CITY OF PORTLAND

3/4/02

Re: 77 Free St. (037 H013) Change of Use/ Storage to Night Club

1 Proposed Basement Demolition Plan
Scale: 1/4" = 1'-0"

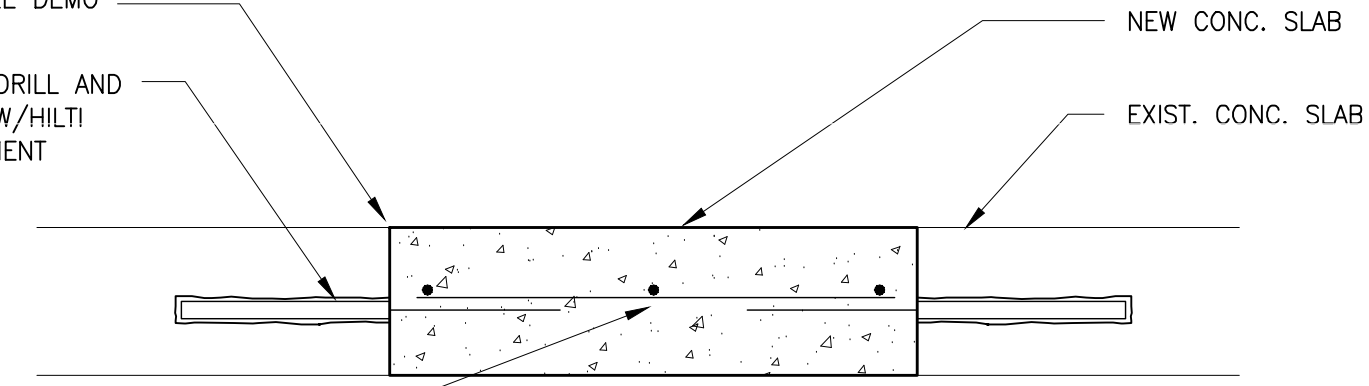
- 1) Details of fire separation assemblies for the Tenant "b" storage areas, the means of egress stairways, The Ceiling assembly from the use upstairs.
- 2) Complete structural details outlining the concrete demo work and associated safeguards/restructuring details.
- 3) Complete structural/construction details of the "Grand Entrance" and the "B
- 4) Structural details that show walls "A" though "H"
- 5) Structural details for the "Coat Check" , "DJ Booth" , "VIP Booth" and "Cooler"
- 6) Structural Details for all raised floor systems (Rec Room, Band Platform etc.) Bar A and Bar B
- 7) Number of toilets and lavs
- 8) Complete Mechanical plans showing Plumbing, Electrical, Heating, and Sprinkler System.
- 9) A State Fire Marshall's Permit
- 10) Cost Estimates for all of the proposed work.
